MIAG and Mcl PC written submissions from oral presentation;

Traffic; Junction 24;

MIAG – Comments on re-designed Inworth Road Roundabout

01-03-2023

Map Book 5: B1023 Roundabout

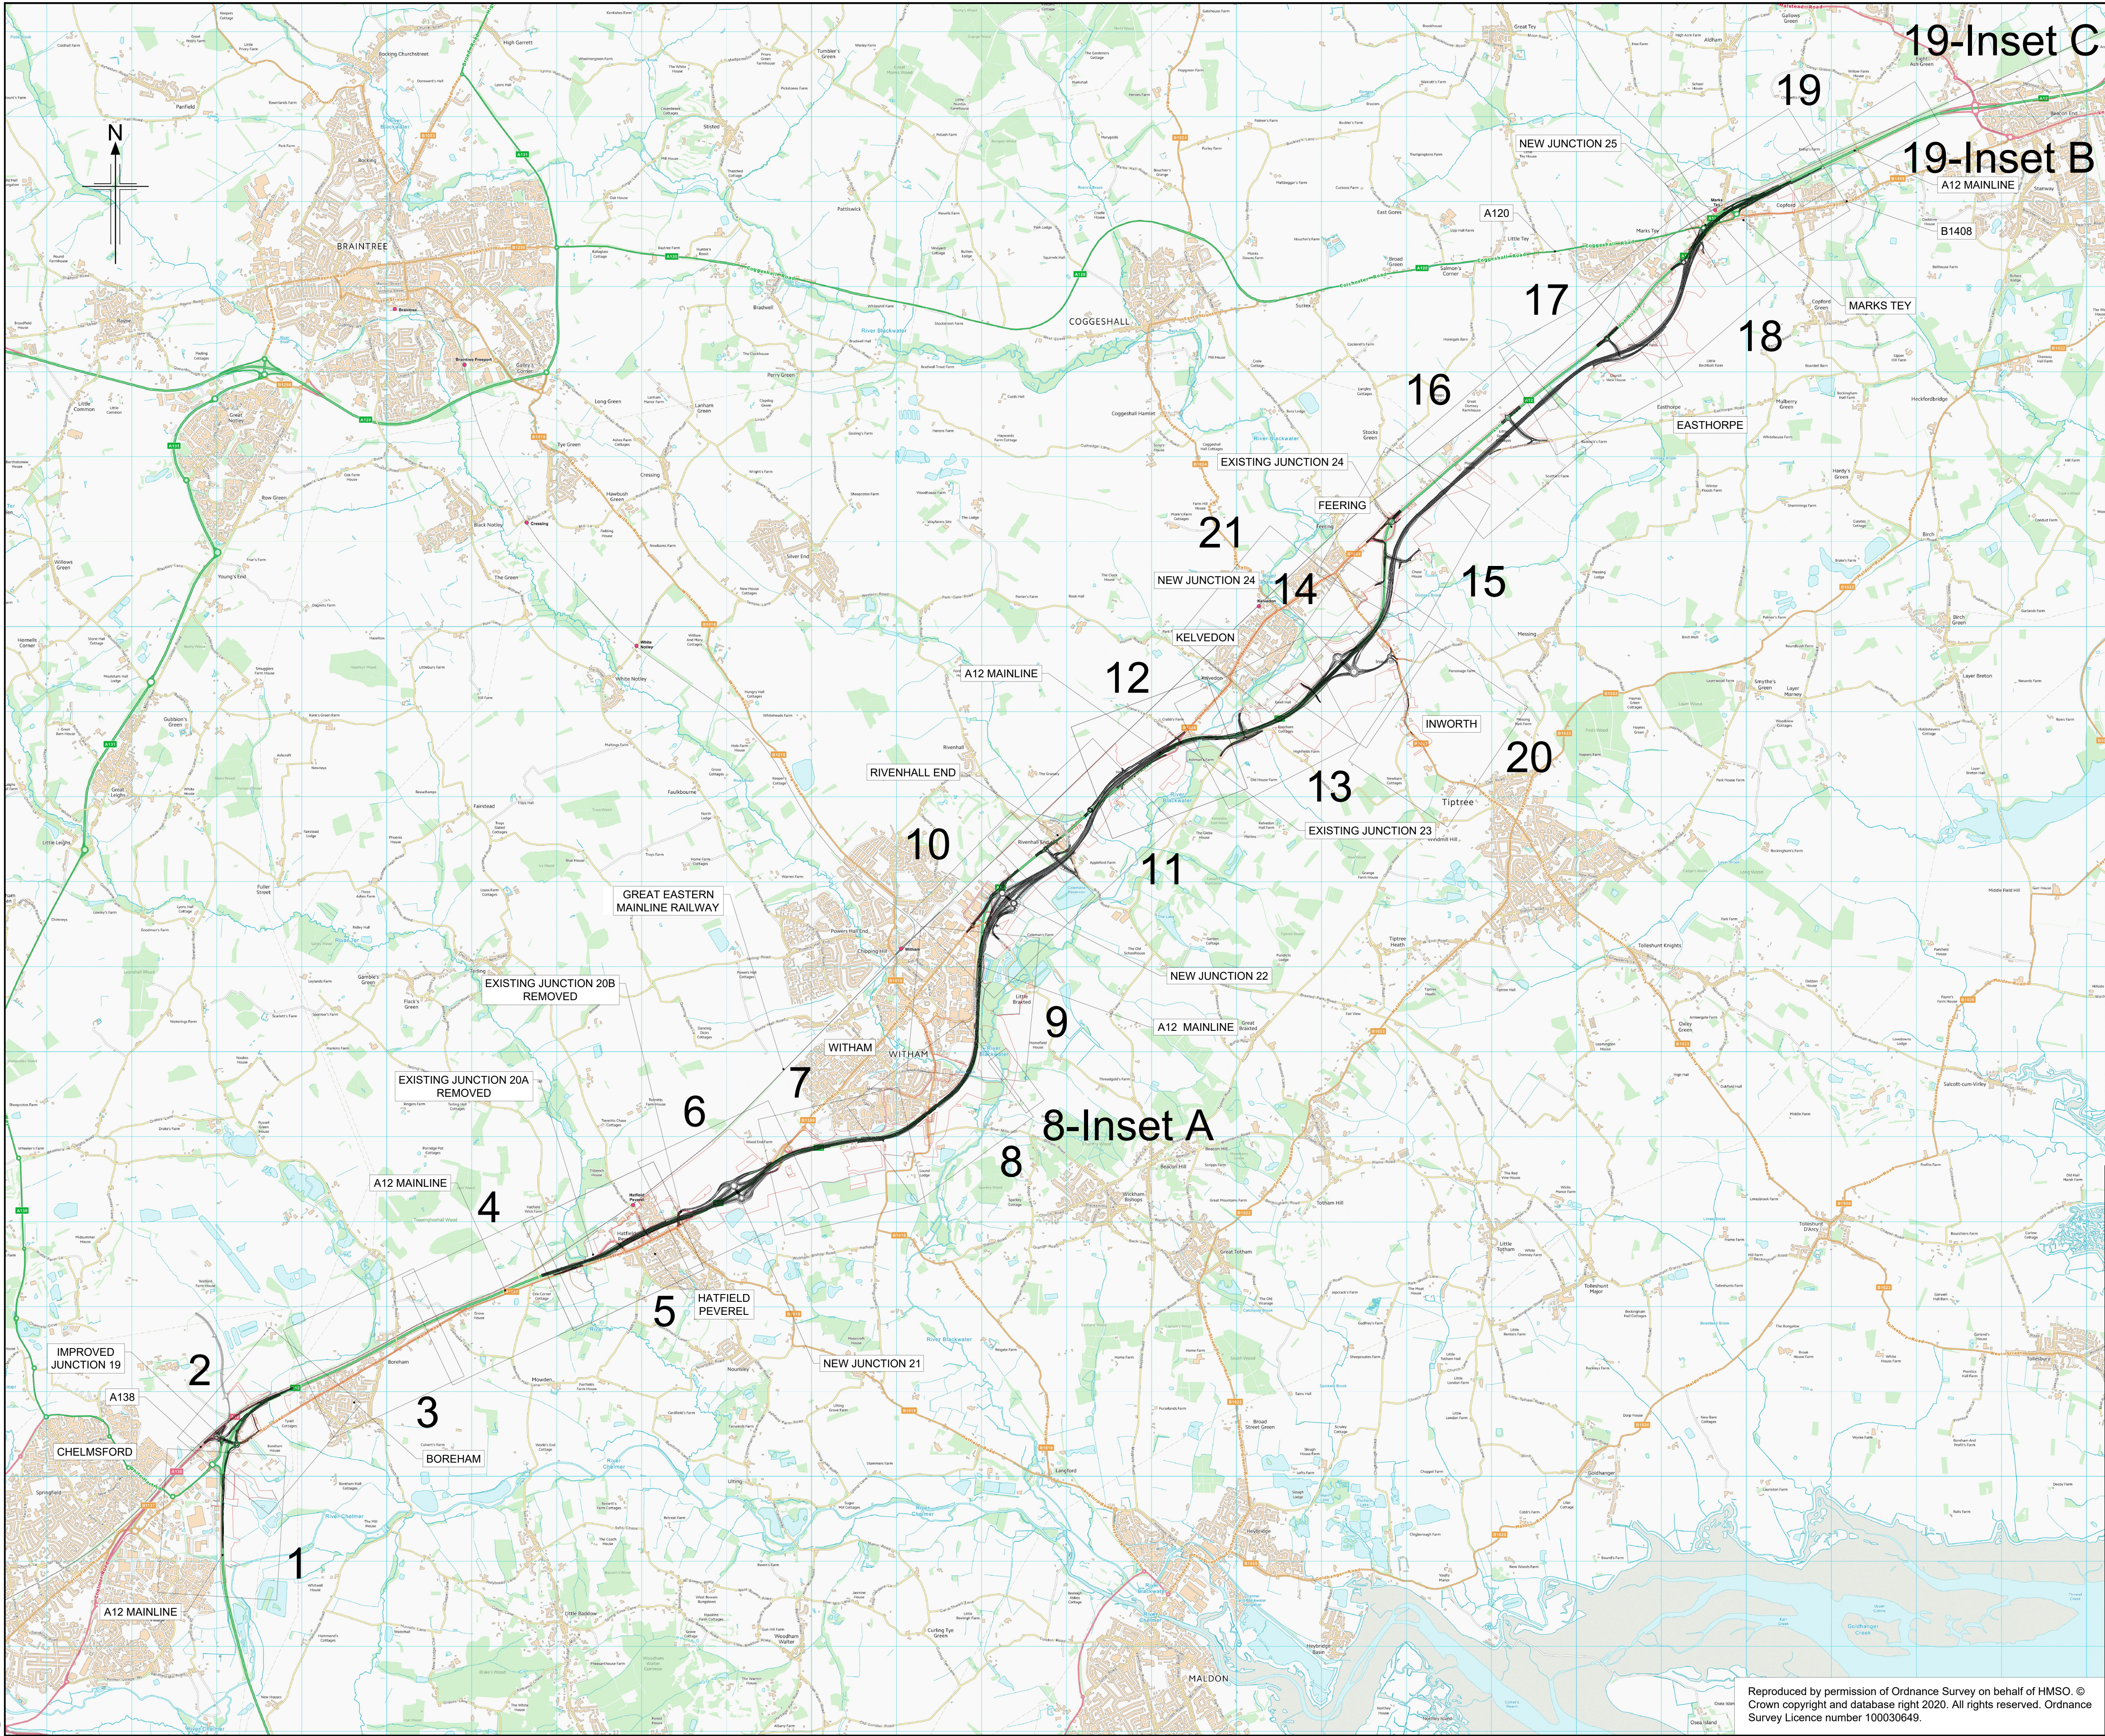
3. Up to this sudden volte face NH continued to deny any errors in their plan;
4. Despite not having more than 6 hours to review this plan, MIAG and Mcl PC already note the incorrectly designed SLTL has been removed.

This re-design removes the largely redundant Segregated Left Turn Lane, which did not comply with Design Manual for Roads and Bridges standards in any case. There is also a variation in the geometry of the Inworth Road north approach arm. The centreline horizontal radius of 67.5 m has been increased to 75.0 m compared to the design submitted in the DCO application.
